Reference No:	2023/62/92795/W
Site Address:	37, Upper George Street, Springwood, Huddersfield, HD1 4AW
Description:	Erection of single storey rear extension and alterations to convert existing dwelling into House of Multiple Occupation (within a Conservation Area)
Recommending Officer:	Lucy Taylor

DECISION – REFUSED

Officer Report

Reference: 2023/92795

PROPOSED BACK ELEVATION  
SCALE: 1:75

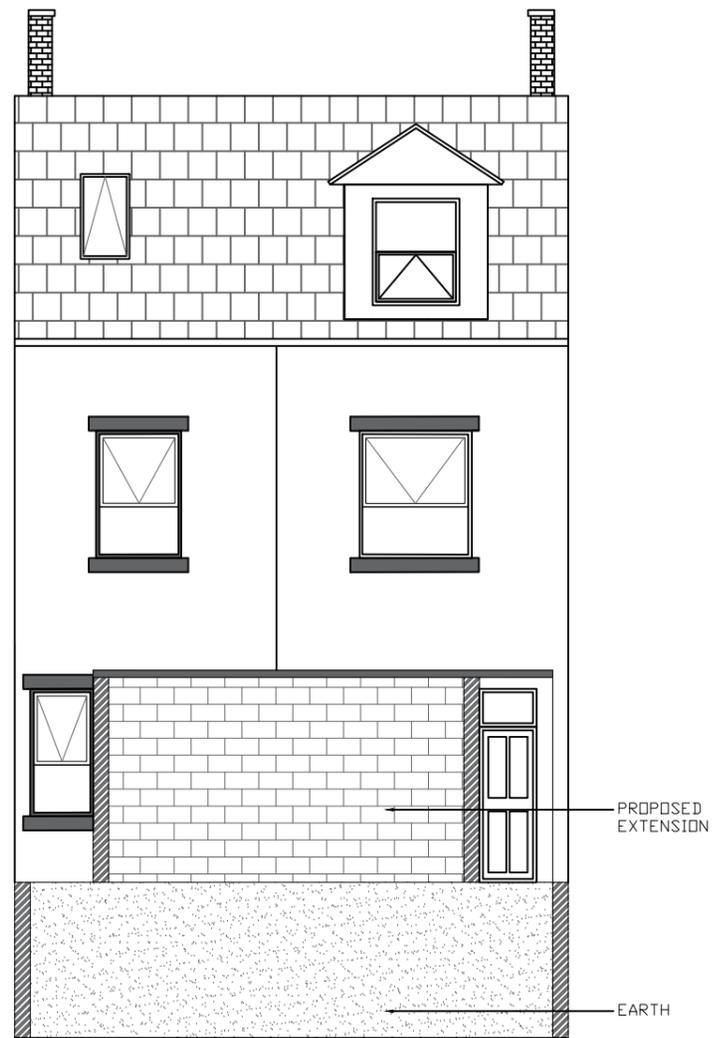
KC Conservation and Design concluded that the proposal is for an overtly dominant extension within the Conservation Area, which would be experienced within the context of the wider streetscene. The design of the extension is considered to be entirely incongruous (accounting for other small-scale extensions in the vicinity) and, regardless of materials, the large expanse of flat roof would be out of keeping.

STRUCTURAL LAYOUT - GF  
SCALE 1:100

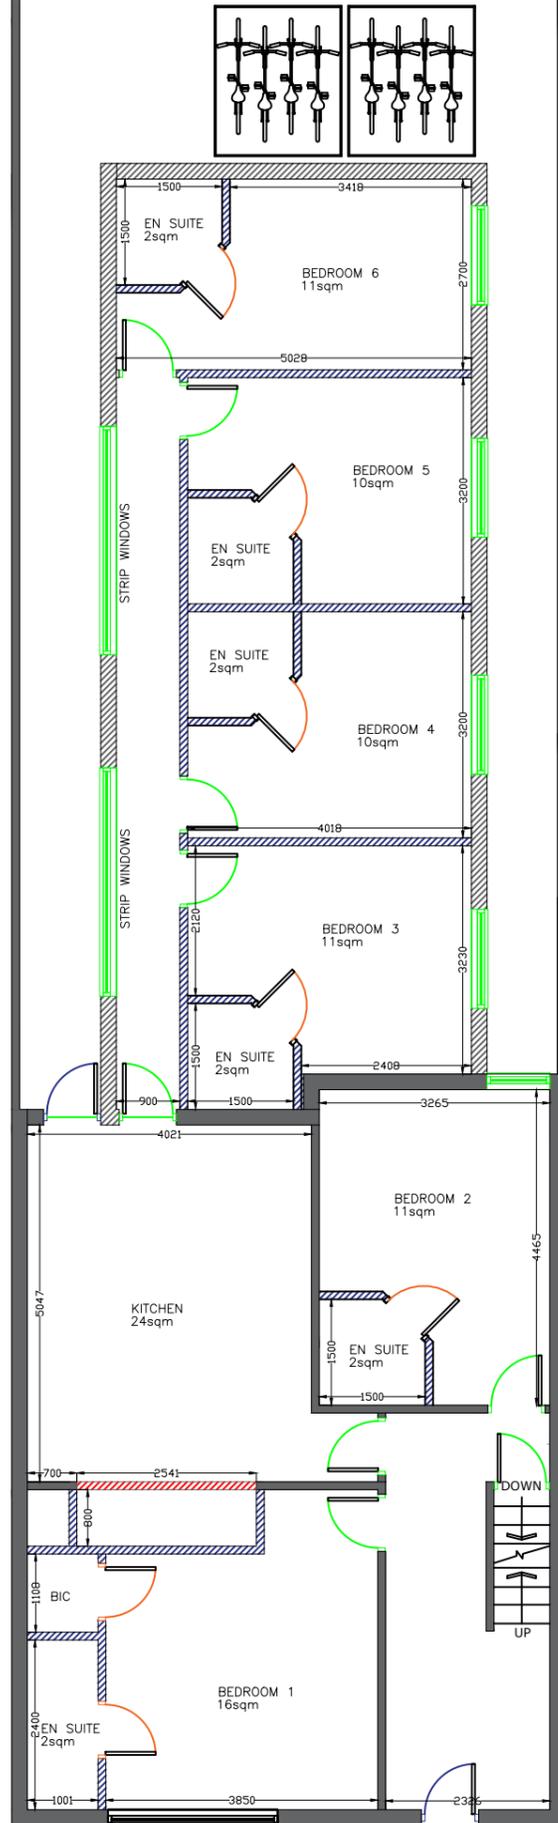
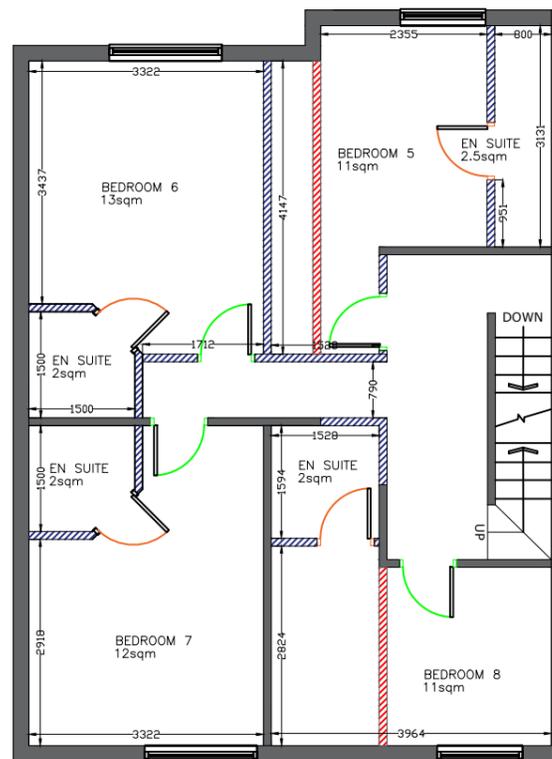
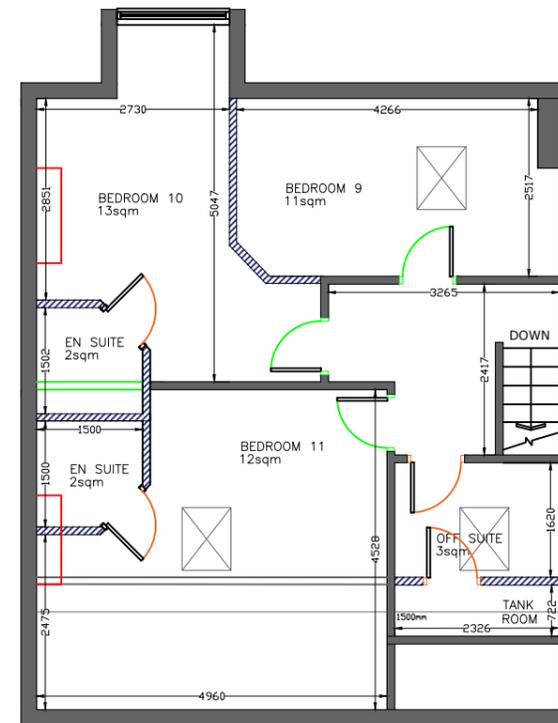
The floorplans submitted show each bedroom to have a double bed, denoting that each bedroom could serve two occupiers. Officers have calculated that some of the bedrooms within the interior of the building would have an internal area of less than 18.6m², for example, bedroom 2 to the ground floor would have an internal area of approximately 14.5m². In addition, one of the bedrooms to the second floor raises concern regarding its floor to ceiling height.

Furthermore, two of the bedrooms to the second floor would only be served by velux windows. This raises concern, with the occupants of these bedrooms likely to suffer from poor levels of amenity. This would be contrary to Policy LP24 (b) of the Kirklees Local Plan and Chapter 12 of the NPPF.

However, the cinema room is to be located within the basement, giving the impression that occupants could spend a large majority of their time underground. The cinema room would only be served by two lightwells of a limited size/scale.

PROPOSED SITE PLAN
SCALE: 1:100

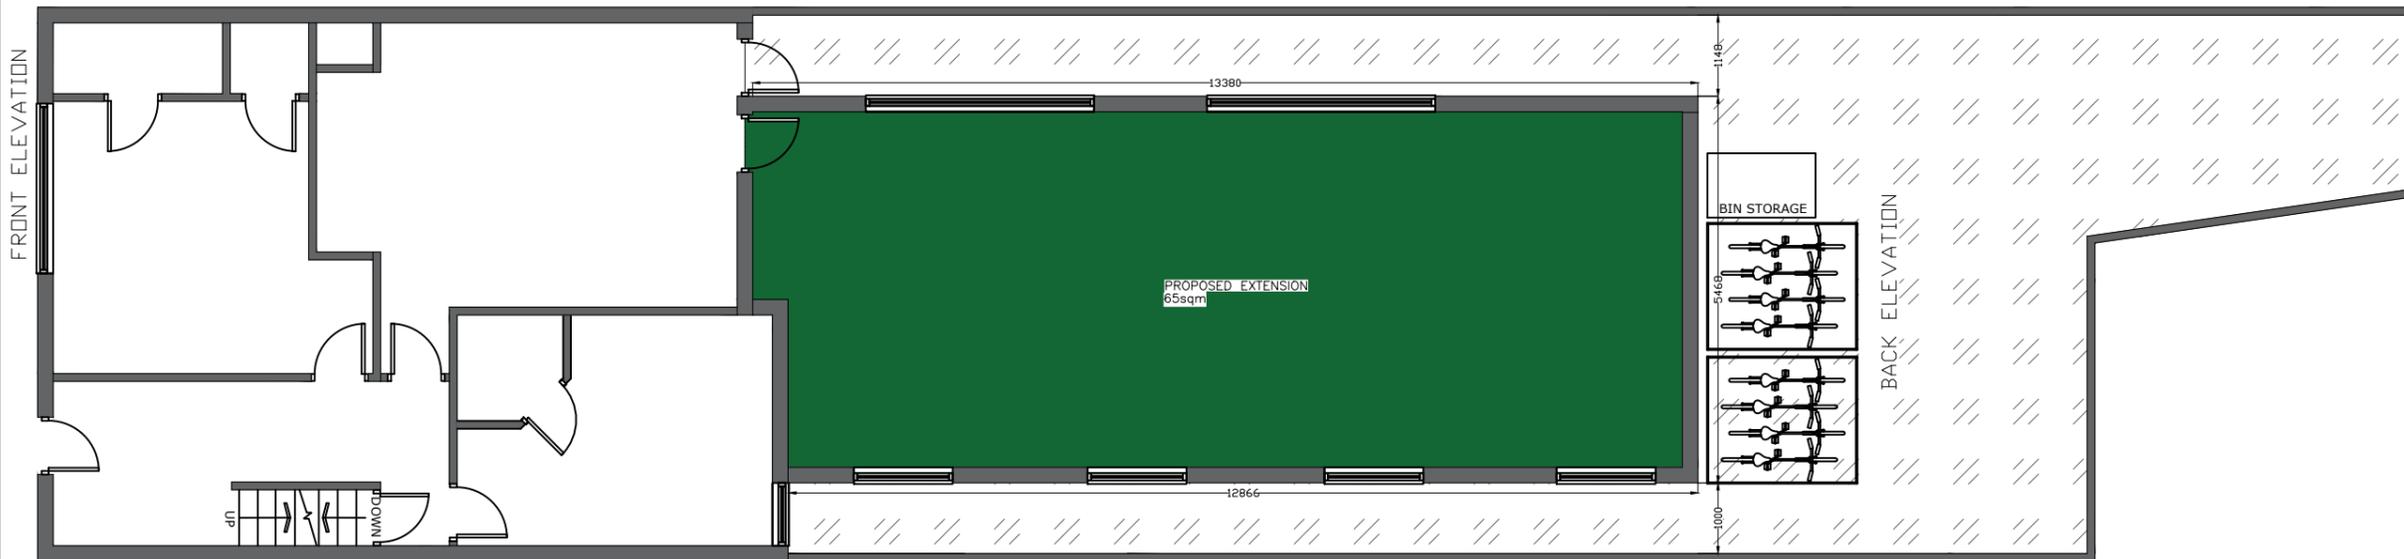
In terms of design, the proposal seeks to erect a single storey rear extension, which projects 13 metres from the rear elevation of the host property. Given the size/scale of the proposed single storey rear extension, it is not

The proposed extension has been calculated to present a footprint of approximately 72m², with the existing ground floor of the property having a footprint of approximately 80m². Therefore, the proposed extension would nearly double the size of the existing ground floor. In turn, these measurements emphasise that the proposed extension would result in a disproportionate addition, that would lead to undue levels of bulking and massing.

Furthermore, the development would be clearly visible and prominent from public vantage points along the highway of Back Spring Street. In turn, the proposed extension has the potential to harm the character and appearance of the dwelling in the wider streetscene, whereby the property sits in the context of a row of terrace properties, where a strong sense of similarity is established.

The proposed single storey rear extension would cut a line of 45-degrees across the entire rear elevation of neighbouring No. 39 Upper George Street and therefore, the extension is concluded to result in undue impacts of overbearing and overshadowing for the occupiers of this neighbouring property.

The proposed single storey rear extension would also cut a line of 45-degrees across the entire rear elevation of neighbouring No. 35 Upper George Street. Therefore, the extension is also concluded to result in undue impacts of overbearing and overshadowing for the occupiers of this neighbouring property.

With regard to privacy, the extension proposes windows in the western facing elevation of the extension, to serve bedrooms. The introduction of these bedroom windows at ground floor level would result in overlooking at close quarters, posing detriment for the occupiers of No. 39 Upper George Street as a consequence of a loss of privacy to their rear garden amenity space.

In terms of the provision of outdoor amenity space, following the erection of the single storey rear extension, a very limited extent of outdoor space would be left, which given its width to the boundary of only approximately 1 metre and its layout would not be adequately useable for future occupiers.
